NSW RURAL FIRE SERVICE

Your reference: SSD 5535
Our reference: S14/0031

SSD 5535– Wahroonga Adventist School, Fox Valley Road, Wahroonga

precinct plan  
 job number 1318.10 dwg. no. / issue & amendment DA02 / 3

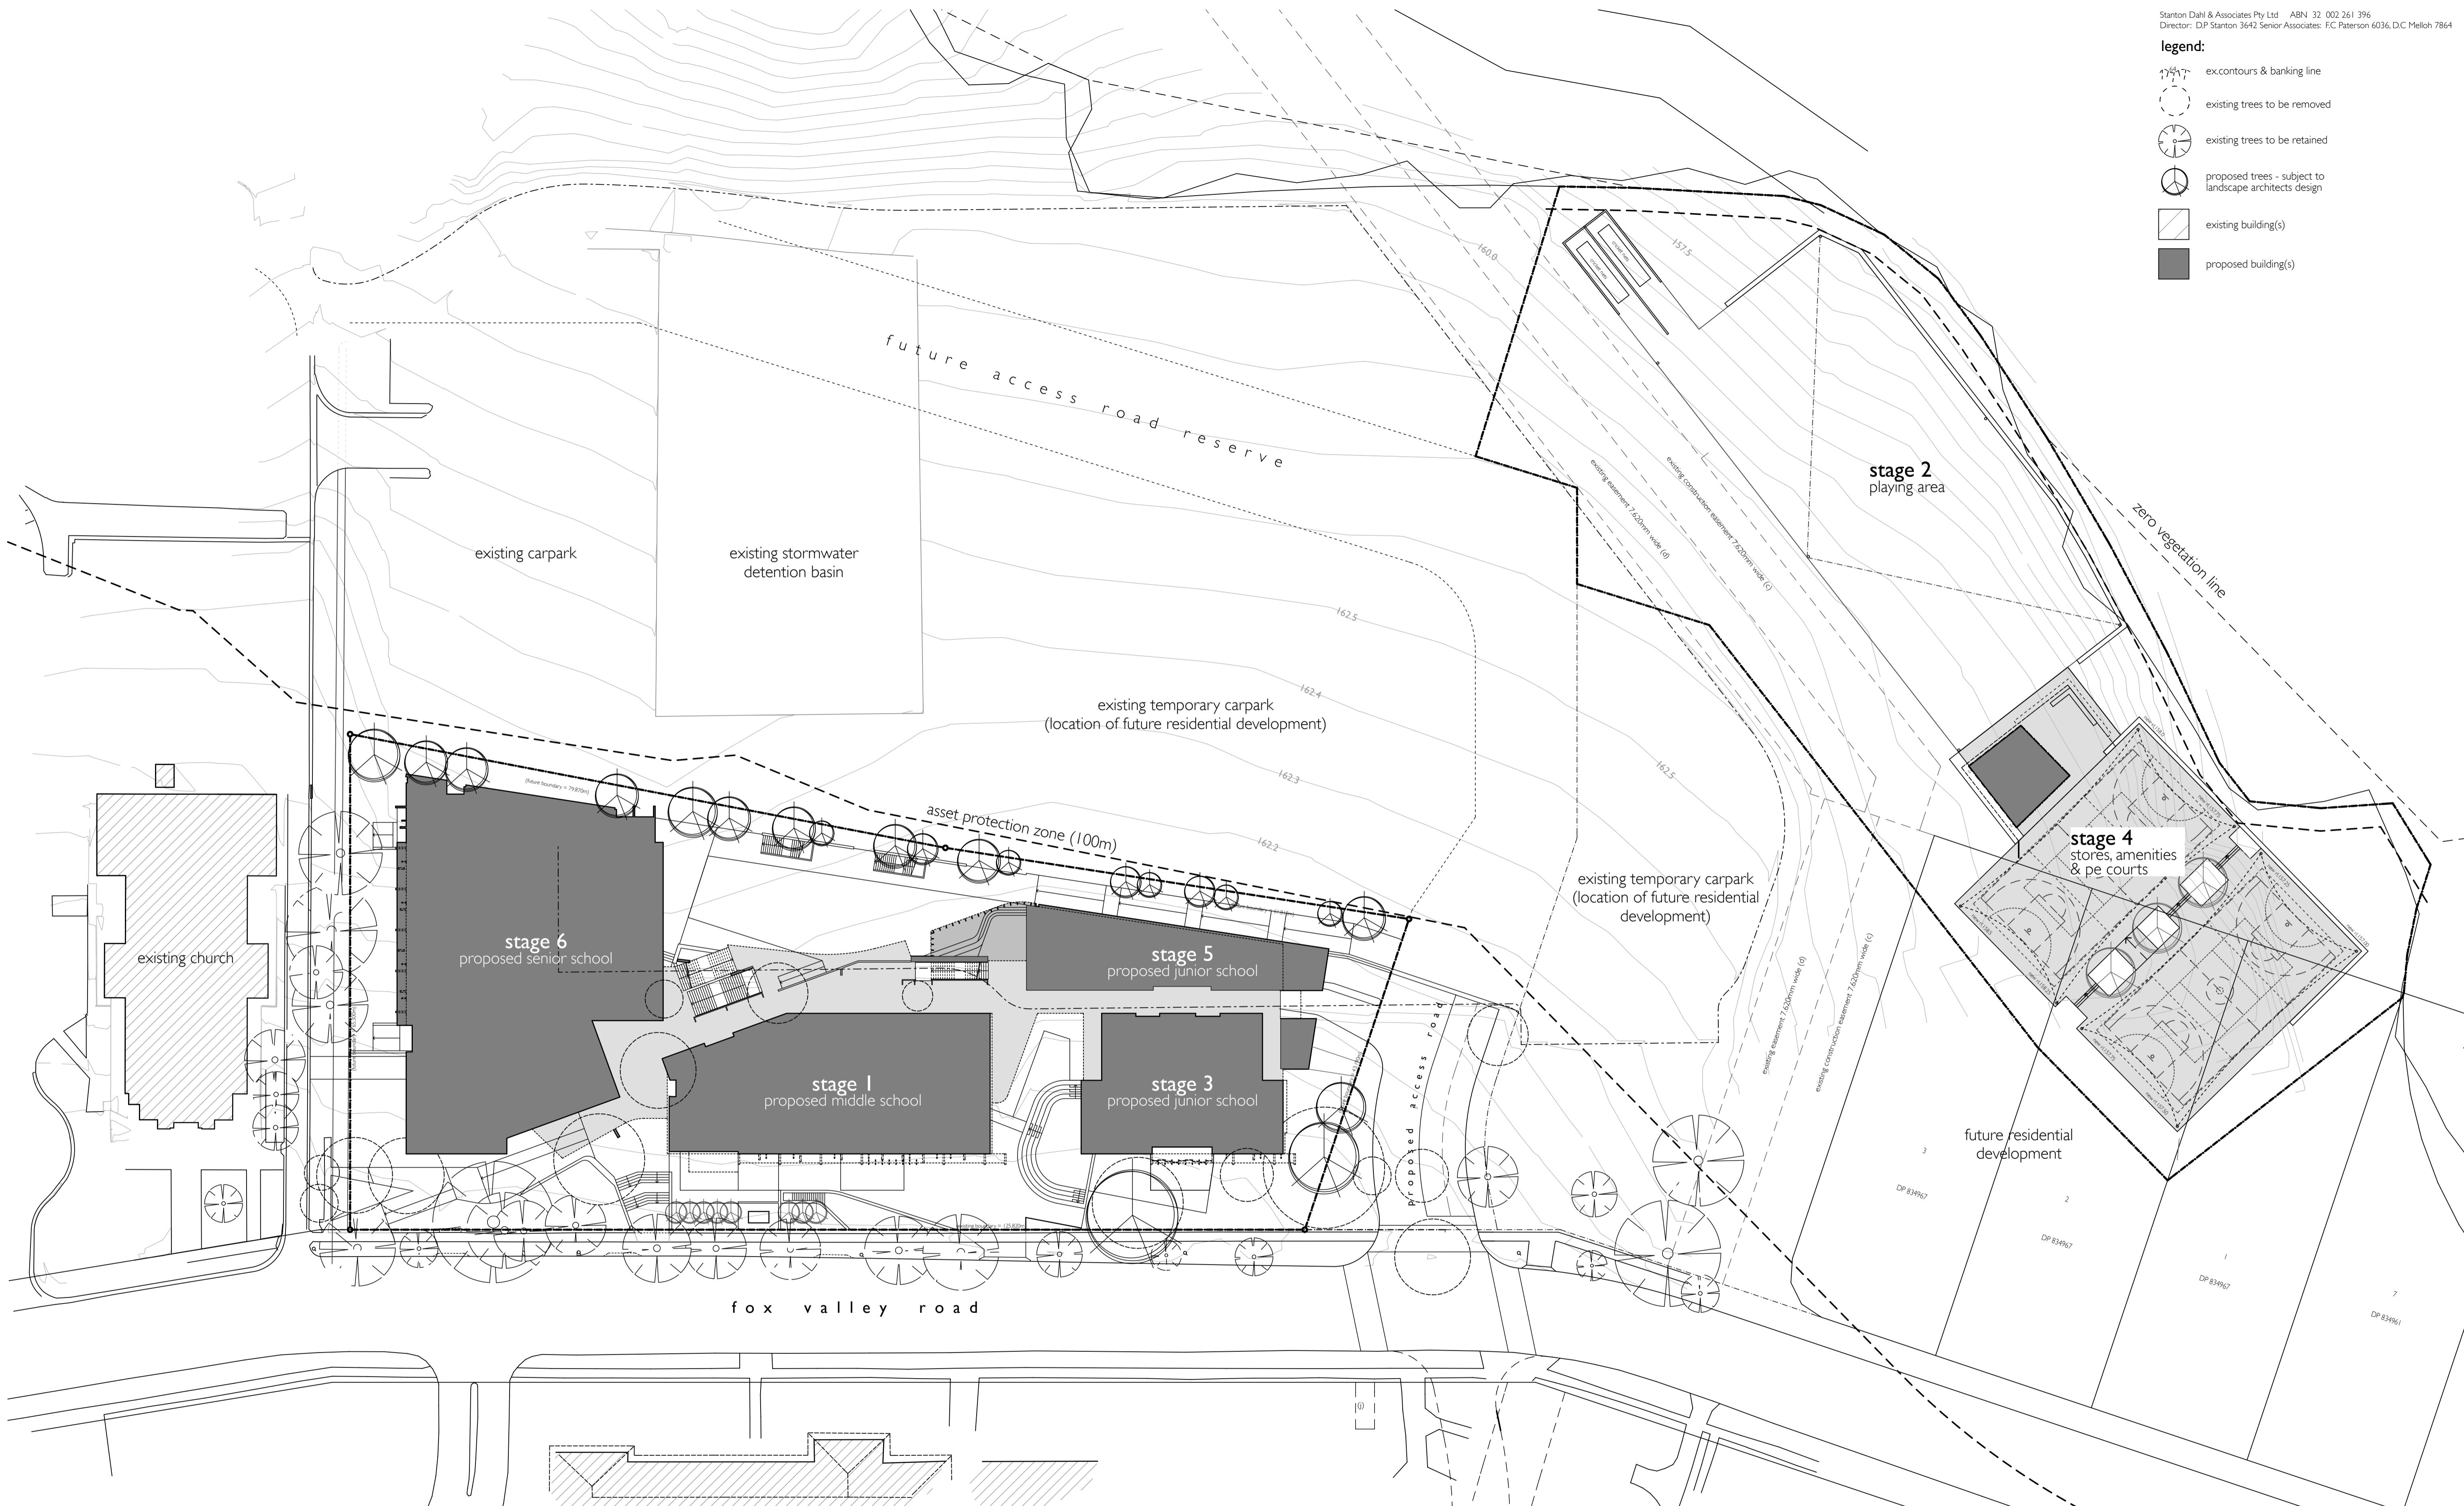
- At the commencement of building works, and in perpetuity, the property around the proposed school buildings on Fox Valley Road shall be managed as an Inner Protection Area (IPA) for a distance of 100 metres as outlined within section 4.1.3 and Appendix 5 of *Planning for Bush Fire Protection 2006* and the NSW Rural Fire Service's document *Standards for asset protection zones*.
- Water, electricity and gas shall comply with section 4.1.3 of *Planning for Bush Fire Protection 2006*.
- Internal road access shall comply with section 4.2.7 of *Planning for Bush Fire Protection 2006*.
- The proposed buildings shall comply with Sections 3 and 5 (BAL 12.5) Australian Standard AS3959-2009 *Construction of buildings in bush fire-prone areas* and section A3.7 Addendum Appendix 3 of *Planning for Bush Fire Protection 2006*.
